A585 Windy Harbour to Skippool Improvement Scheme

TR010035

7.11 Environmental Statement Changes and Corrections Document

July 2019

Rev	Status	Rev. Date	Purpose of revision	Drawn	Check'd	Appr'd
1	SS	MAY19	S8 - DEADLINE 2 SUBMISSION	JN	KB	NH
0	SS	OCT18	S8 - DCO SUBMISSION	JN	KB	NH

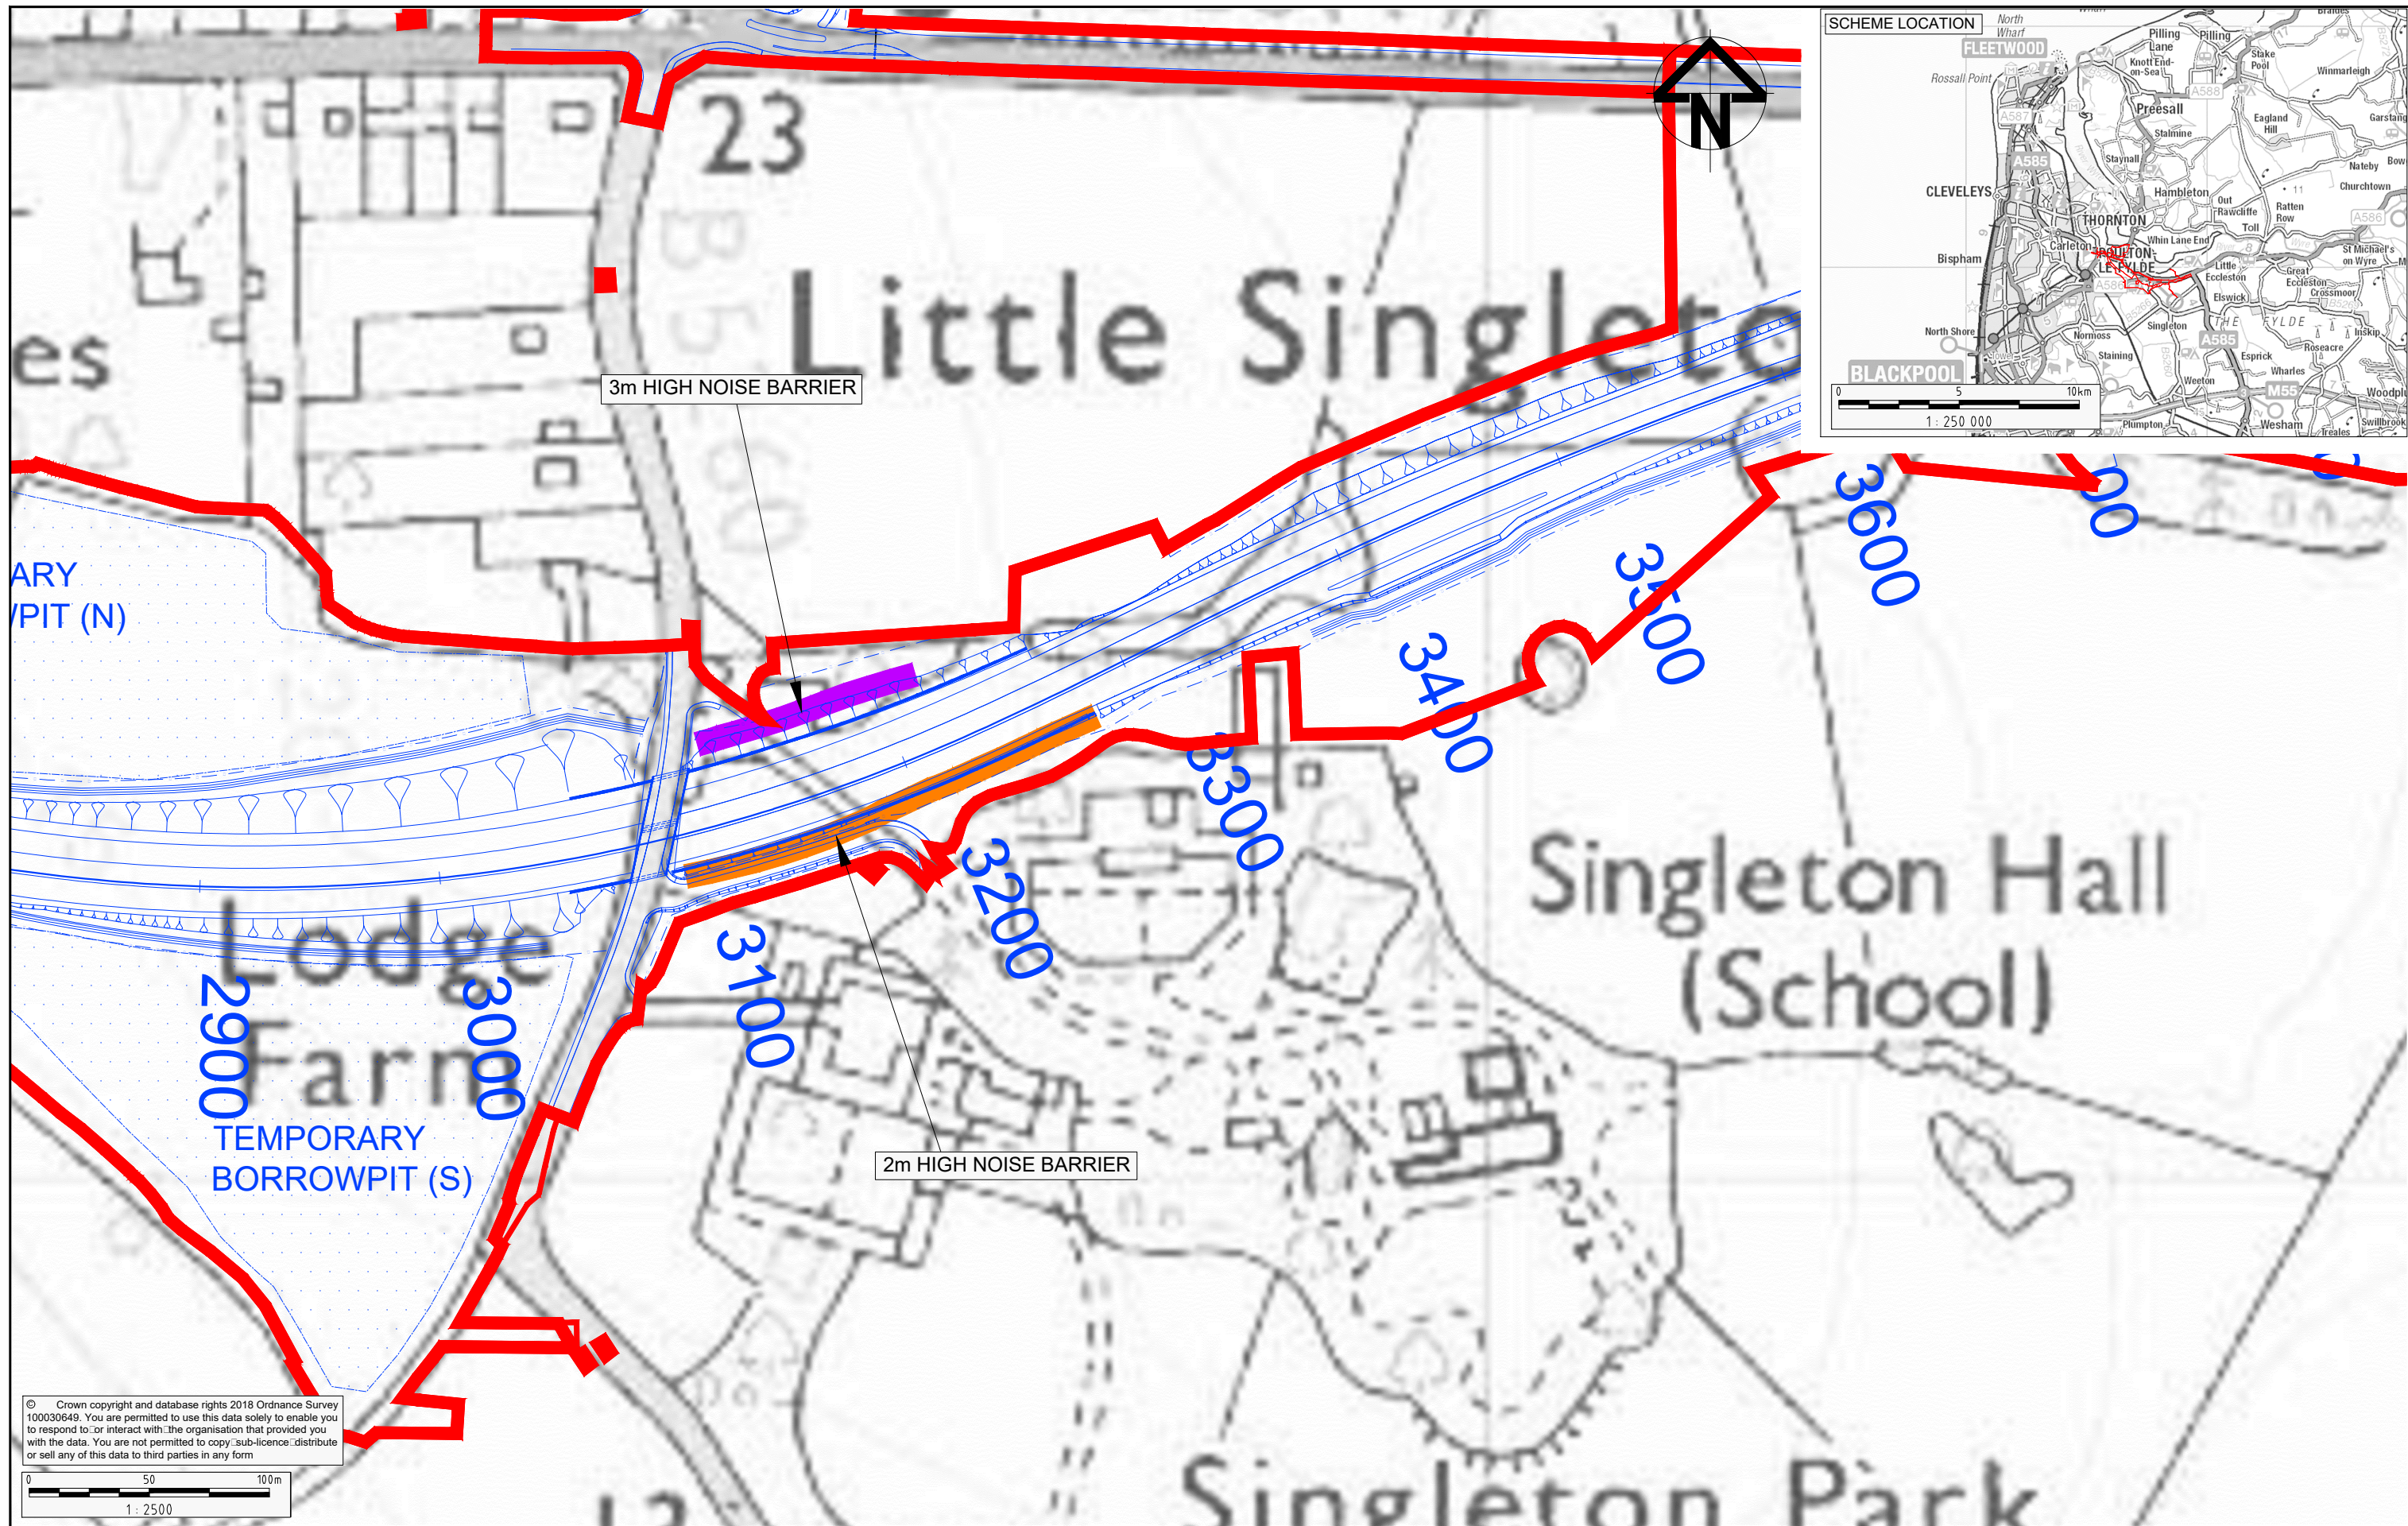
Document Reference Number	Document Name	Amendment Required	Reason
			TR010035/APP/7.10).
6.11	ES Chapter 11: Noise and Vibration	Update to Figure 11.4: Noise and Vibration – Noise Mitigation within the Study Area presented at Appendix D to show heights and locations of earth mounds and acoustic fencing at a larger scale.	Requested by the Inspector within the first round of written questions (document reference TR010035/APP/7.10).

Insert 12-3: Road Drainage and the Water Environment - Maximum flood Extents in Baseline and with Scheme (option model) Scenarios (0.5% AEP tidal event)

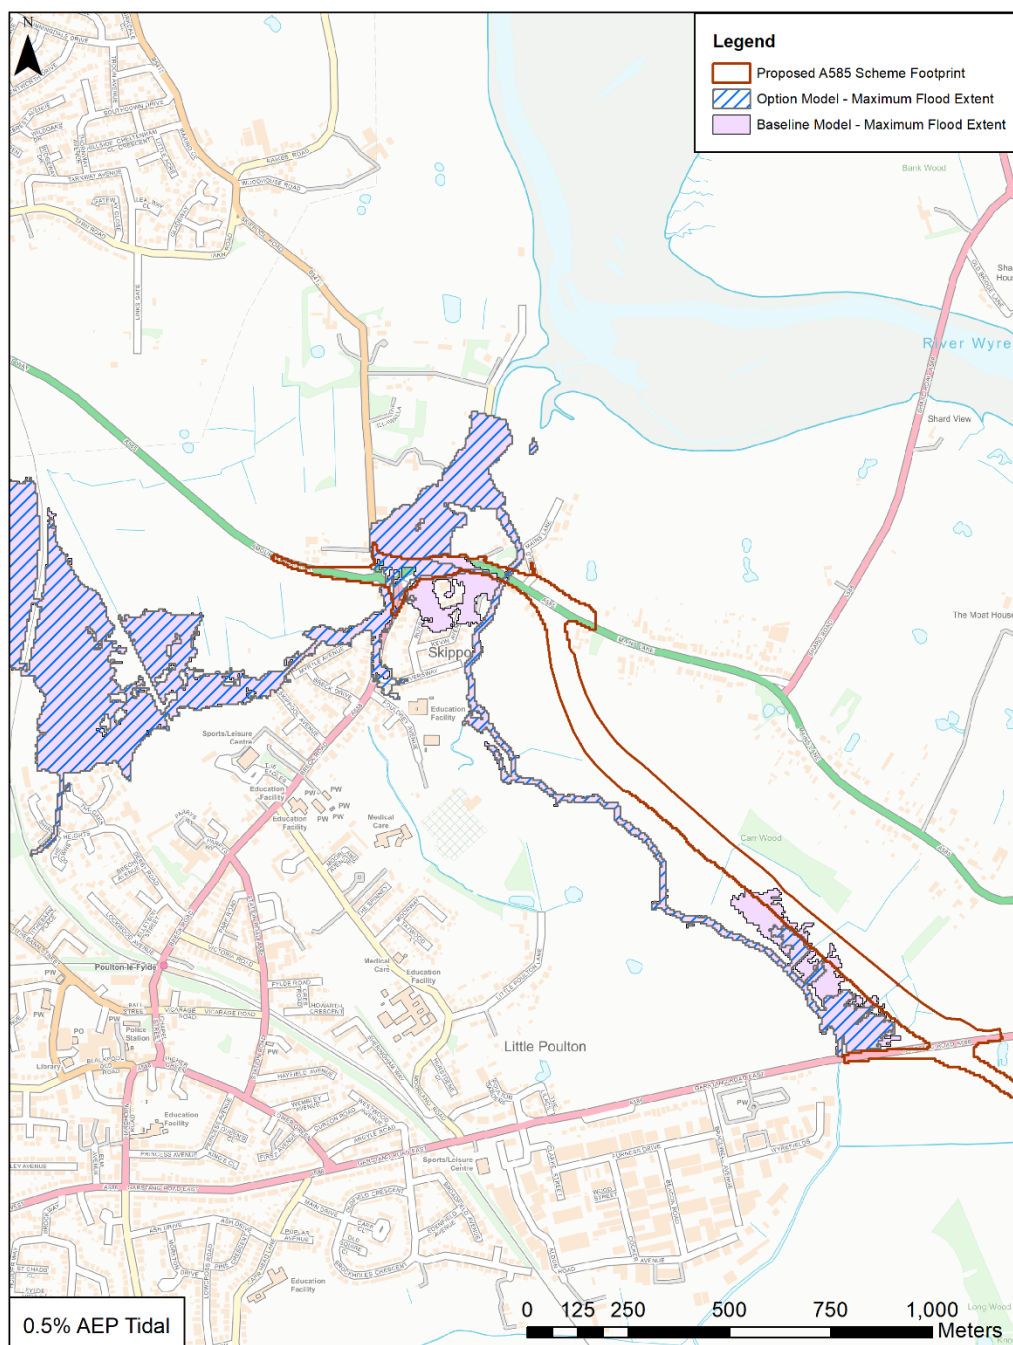
6.12	ES Chapter 12: Road Drainage and the Water Environment	Replacement Insert 12-3: Road Drainage and the Water Environment - Maximum Flood Extents in Baseline and with Scheme (option model) Scenarios (0.5% AEP tidal event).	As a result of the updates made to the Flood Risk Assessment (document reference TR010035/APP/5.2 – Rev 1).
